CDS is requesting comments on the following short plat application: SP-26-00003 Miller.

To: All Staff
From: Environmental Health
Date: 5/15/2026
Subject: SP-26-00003 Miller

TO: All Staff
FROM: Public Works Plan Review Team
DATE: May 13, 2026
SUBJECT: SP-26-00003 Miller

MILLER SHORT PLAT		
PREPARED FOR DON MILLER		
A PORTION OF SECTION 4 & SECTION 33, TWN. 19 N., RGE. 15 E. & TWN. 20 N., RGE 15 E., W.M.		
KITTITAS COUNTY WASHINGTON		
DWN BY <b>G.W.</b>	DATE <b>04/2026</b>	JOB NO. <b>230053</b>
CHKD BY <b>D.L.P.</b>	SCALE <b>1" = 200'</b>	SHEET <b>2 OF 3</b>

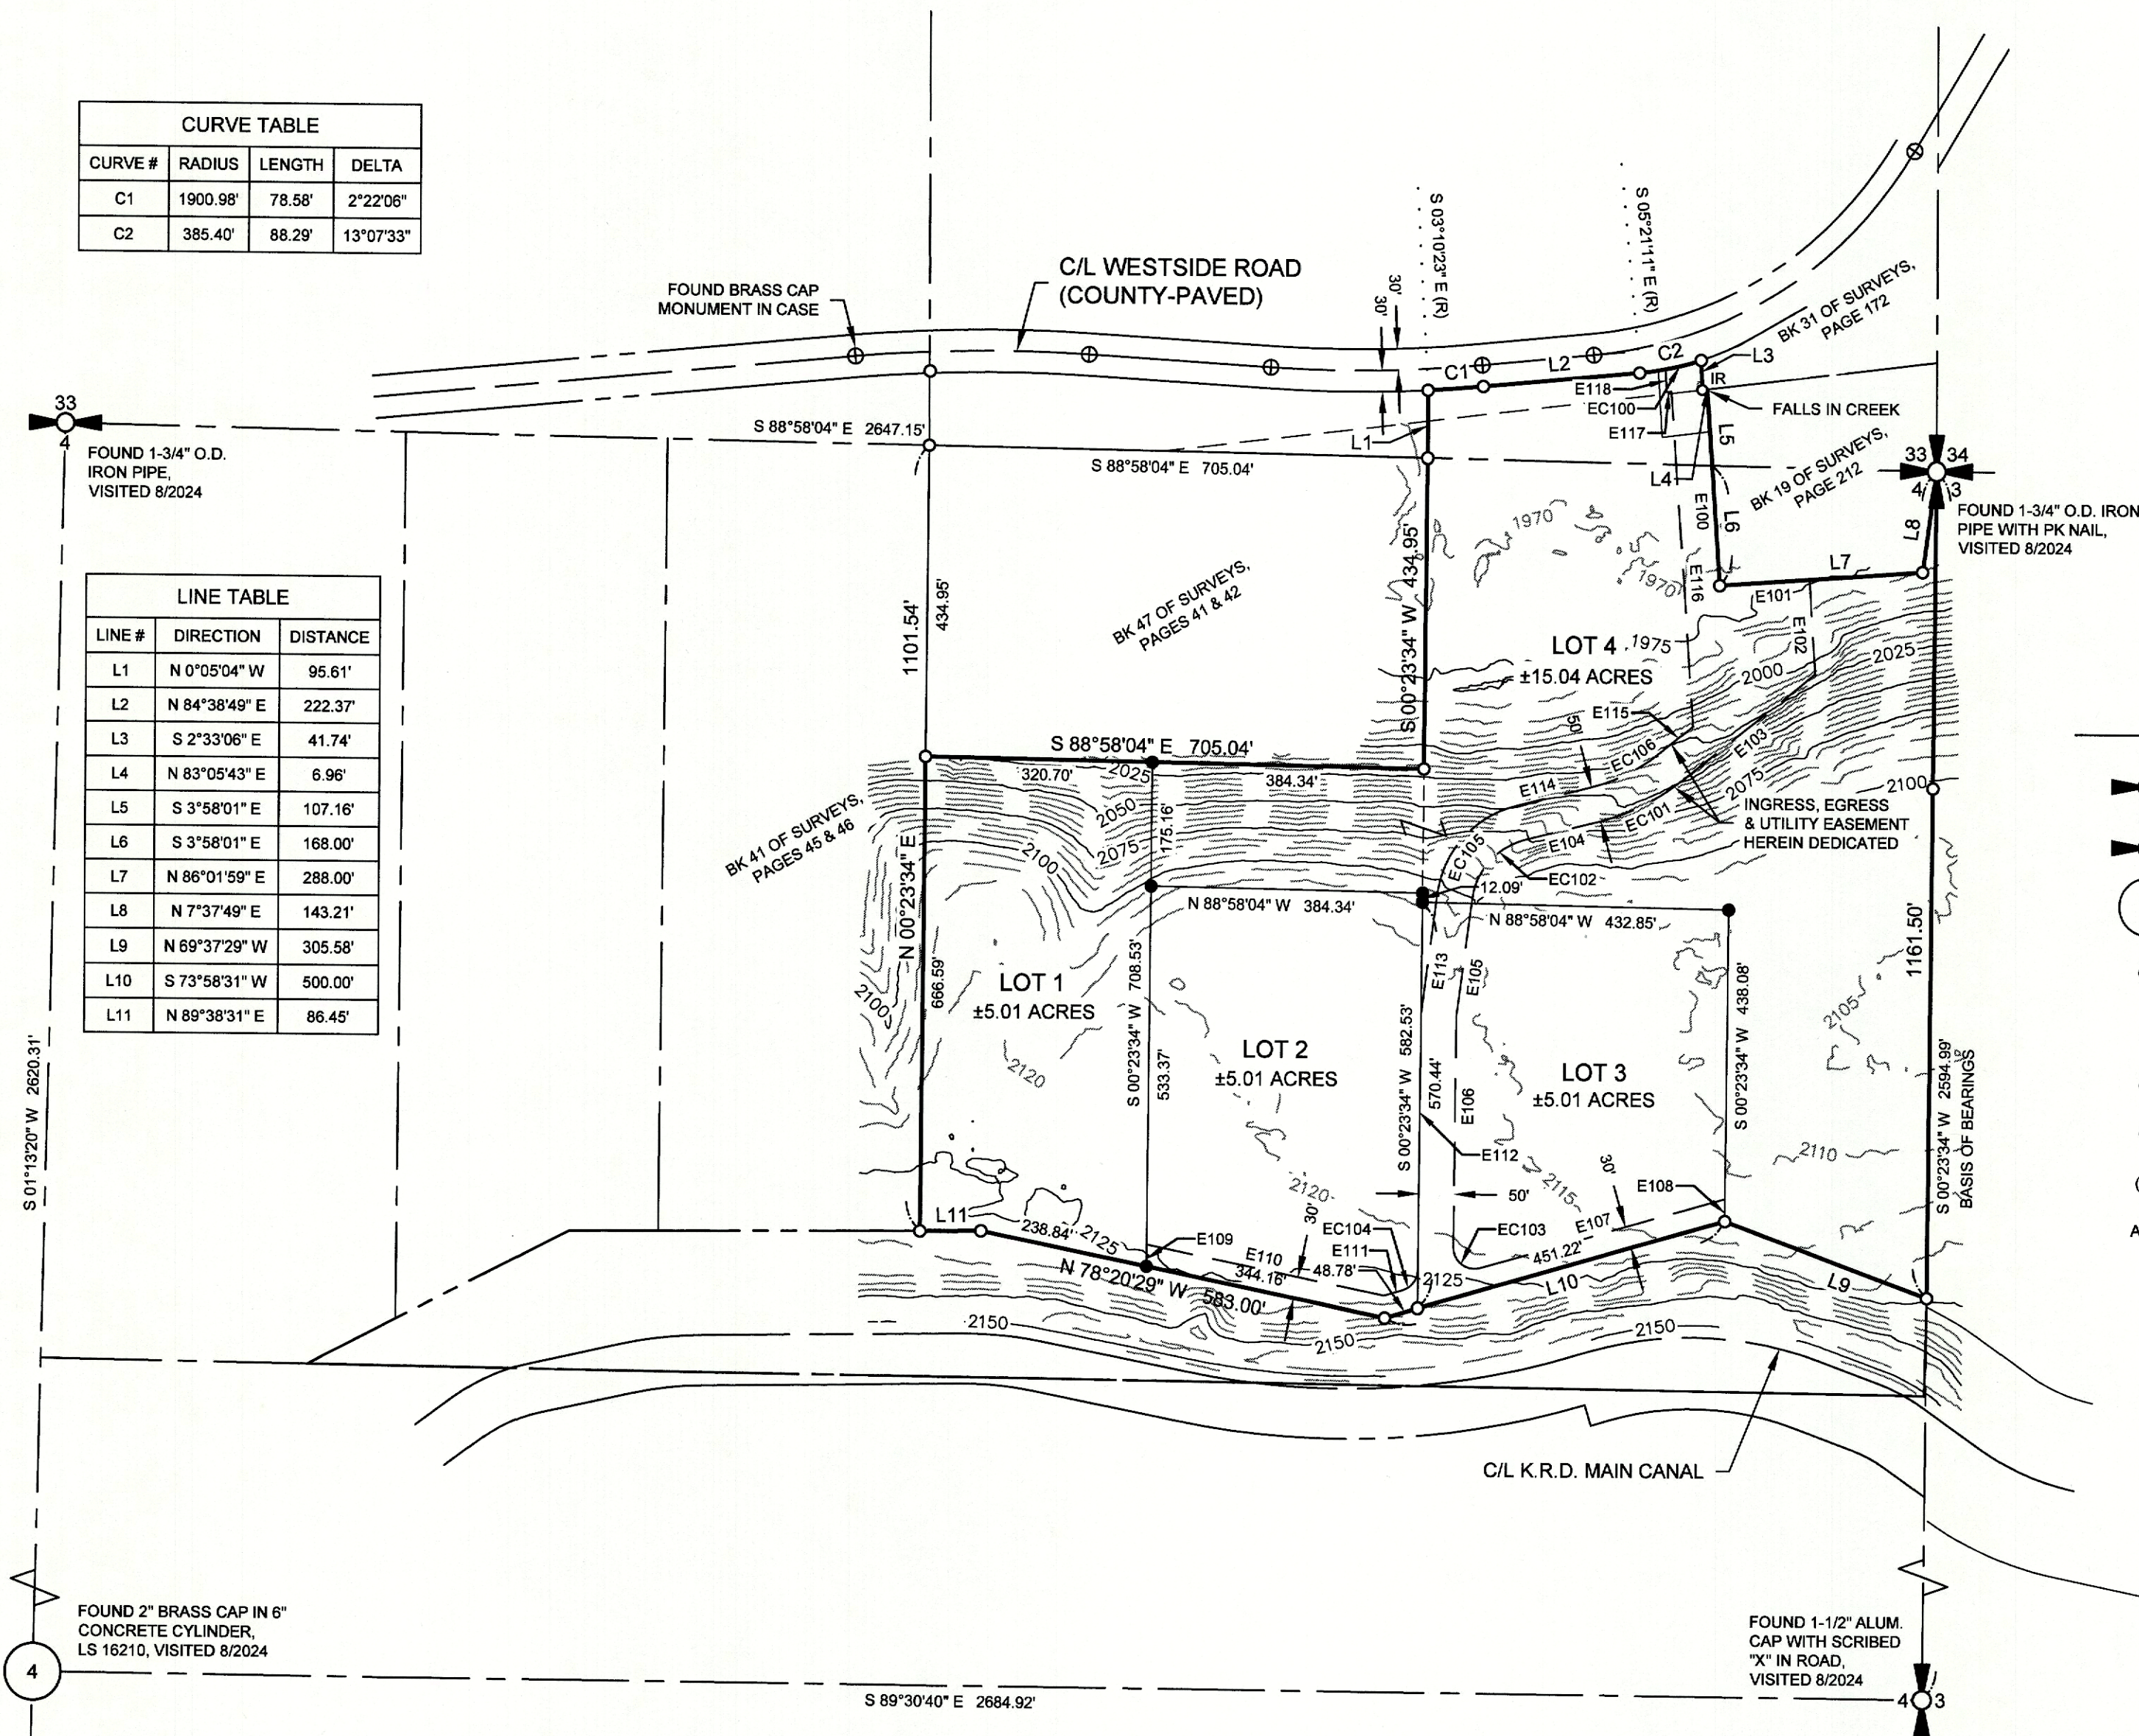
SURVEY	<ol style="list-style-type: none"> 1. Application map does not meet requirements of WAC 332-130-145 Topo Standards. 2. If any road monuments or either of the 2 untied property corners were utilized for survey control, please include distance and bearing ties to these monuments. <p>OF NOTE (change not required for approval)</p> <ol style="list-style-type: none"> 1. The area near the N'most corner of Lot 4 would benefit from a note "See Detail Next Sheet". (JT)
TRANSPORTATION CONCURRENCY	<p>Transportation concurrency not applicable to this project.</p>
